**Application for a non-material amendment following a grant of planning permission.
 Town and Country Planning Act 1990**

Extension & enlargement of existing lobby.

Area ammended - rear single story extension with pitched roof.

1/0482/2019 FUL

North elevation  
existing

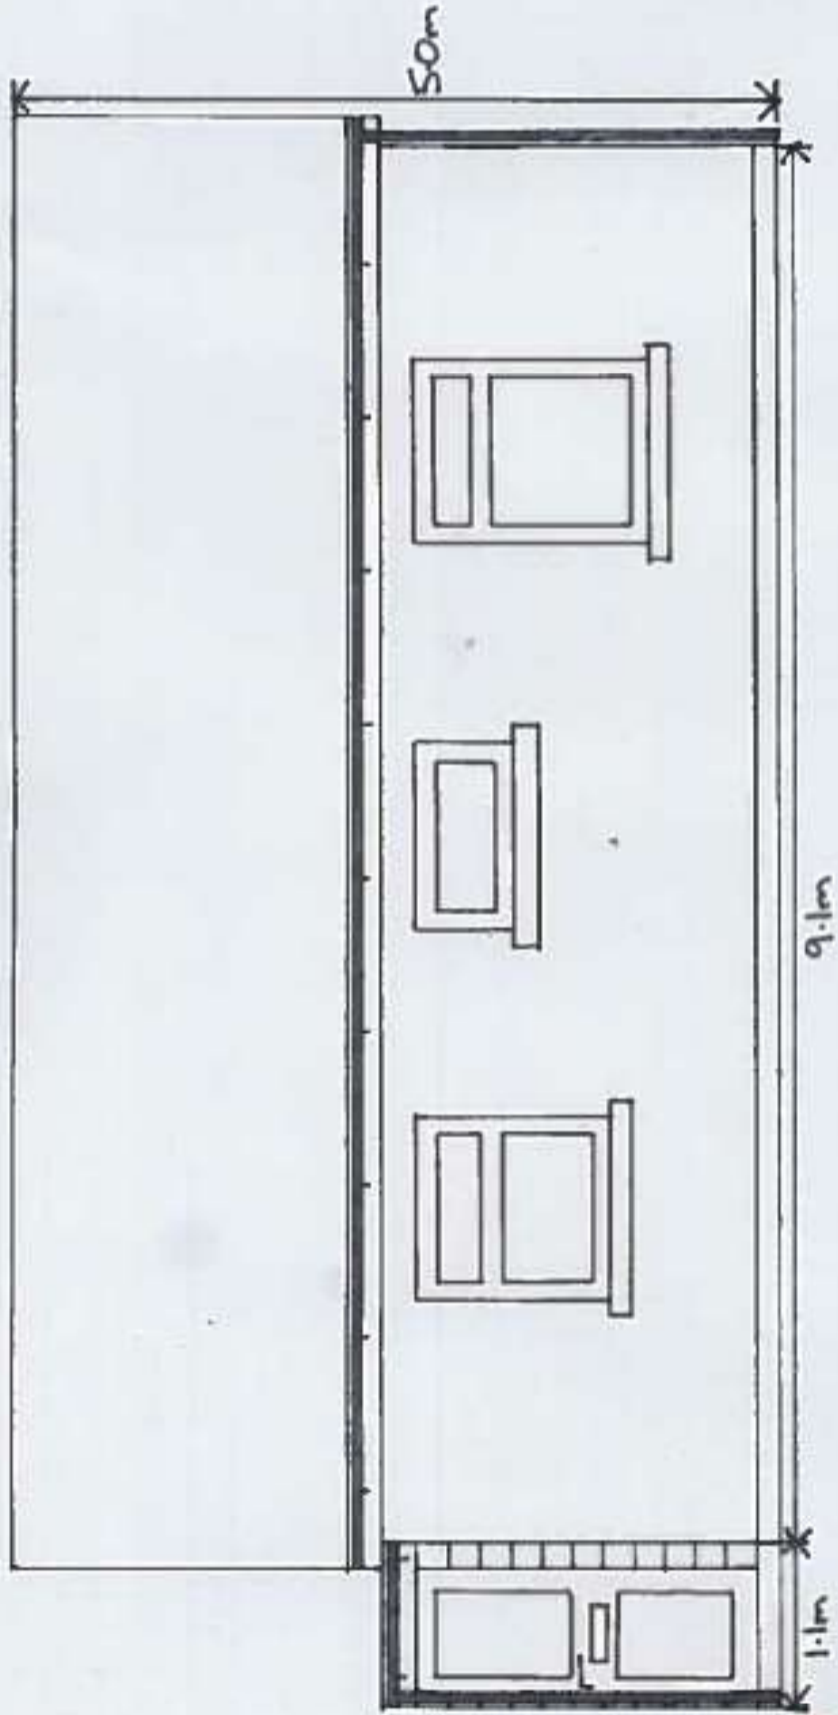
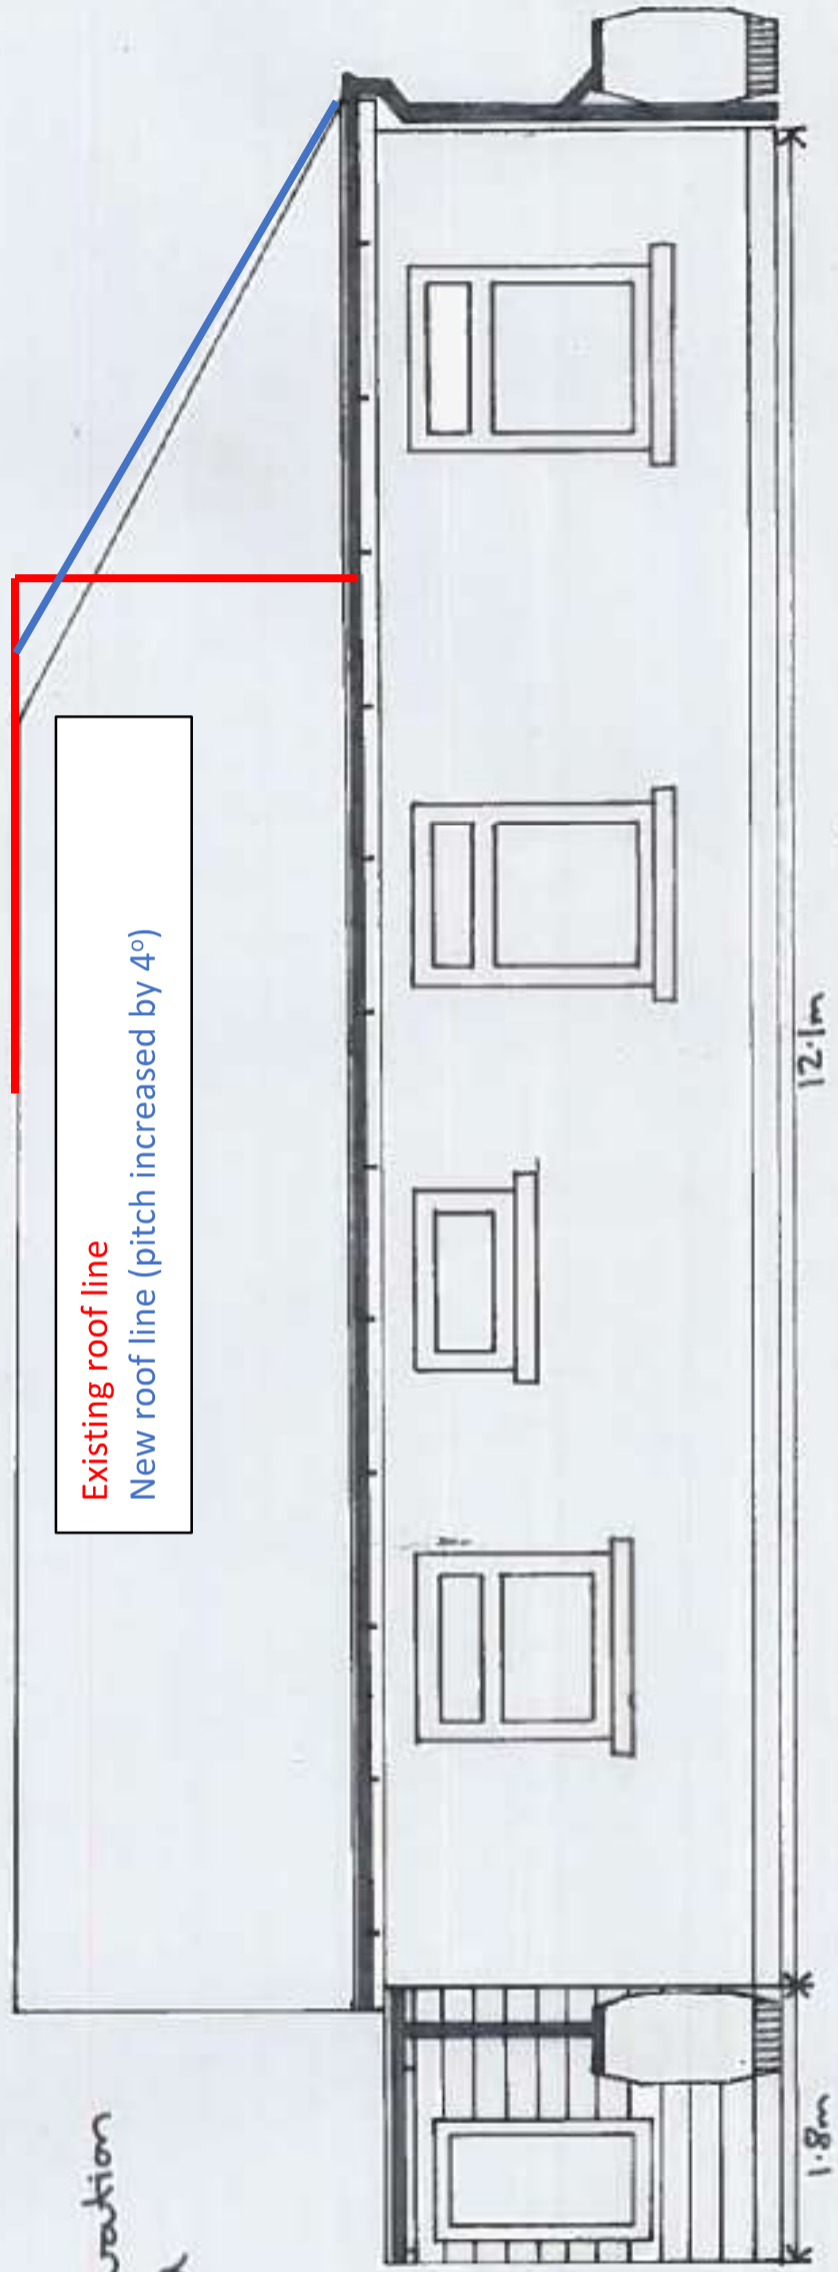
Hipped end of pitched roof to be angled
sleeper by 3 degrees.

Original plan design would mean
we would have had to have made
alterations to existing trusses in roof.
